KIRKLEES METROPOLITAN COUNCIL INVESTMENT & REGENERATION SERVICE

DELEGATED DECISION TO DETERMINE APPLICATIONS FOR LISTED BUILDING CONSENT

Reference No:	2023/65/91237/W
Site Address:	White Syke Farm, Marsden Lane, Marsden, Huddersfield, HD7 6AF
Description:	Listed Building Consent for erection of lean-to car port to western gable end
Recommending Officer:	Lucy Taylor

PROPOSED SOUTH ELEVATION

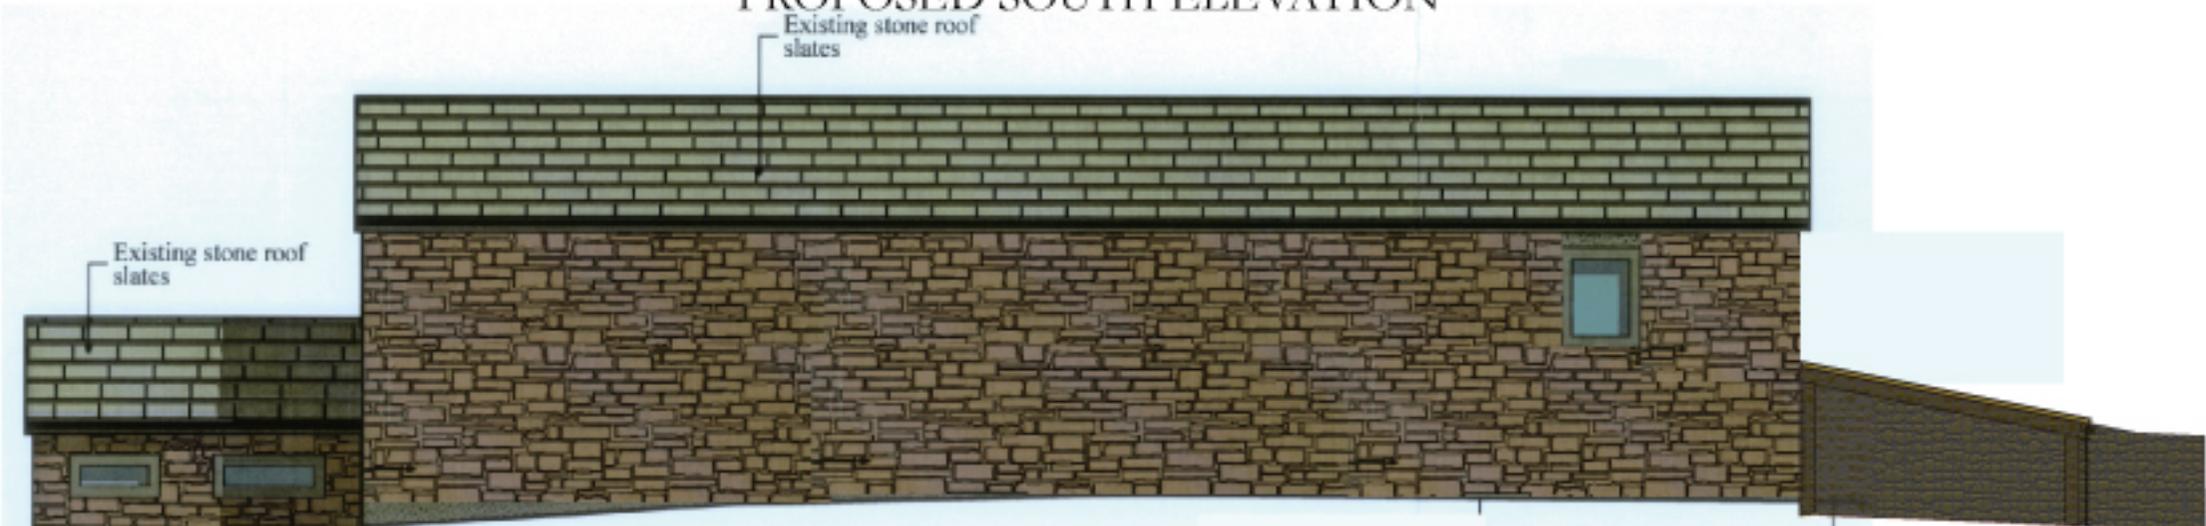
The car port would be constructed from a simple oak frame, with the southern elevation to be left open for vehicle access and natural planting would be used to form screening to the western side elevation. The roof of the lean-to car port would be infilled with grey stone slates.

Following a formal consultation response from KC Conservation and Design, the case officer sought additional detail regarding the construction style of the stepped dwarf wall and amendments to the roof finish of the car port.

KC Conservation and Design - consider the proposed carport to have a degree of impact on the setting of the listed farmhouse, however, given the nature of the structure and its more lightweight and open form, this would be acceptable subject to details been submitted for the stepped wall and amendments been made to the roof finish.

The proposed structure would be of a lean-to construction, with the main frame constructed using oak posts. The structure would essentially be open. The lean-to roof would be infilled with grey stone slate tiles, considered to blend with the character and setting of the building, matching the roof of the host farmhouse and attached barn.

The applicant provided confirmation via email (dated 28th June 2023) that the wall would be a drystone wall and that the roof would be infilled with grey stone slates.

Following this consultation response, the applicant confirmed via email that the wall would be a drystone wall and that the roof of the carport would be infilled with grey stone slates. These finishes can also be secured through condition.

2. The hereby approved extension/car port shall have an oak frame and the lean-to roof shall be finished with grey stone slate tiles. These materials shall in all respects match those used in the construction of the existing building and be thereafter retained.
Reason: For the avoidance of doubt as to what is being permitted and so as to preserve the significance of the heritage asset and to comply with Policy LP35 of the Kirklees Local Plan and Policy within Chapter 16 of the National Planning Policy Framework.
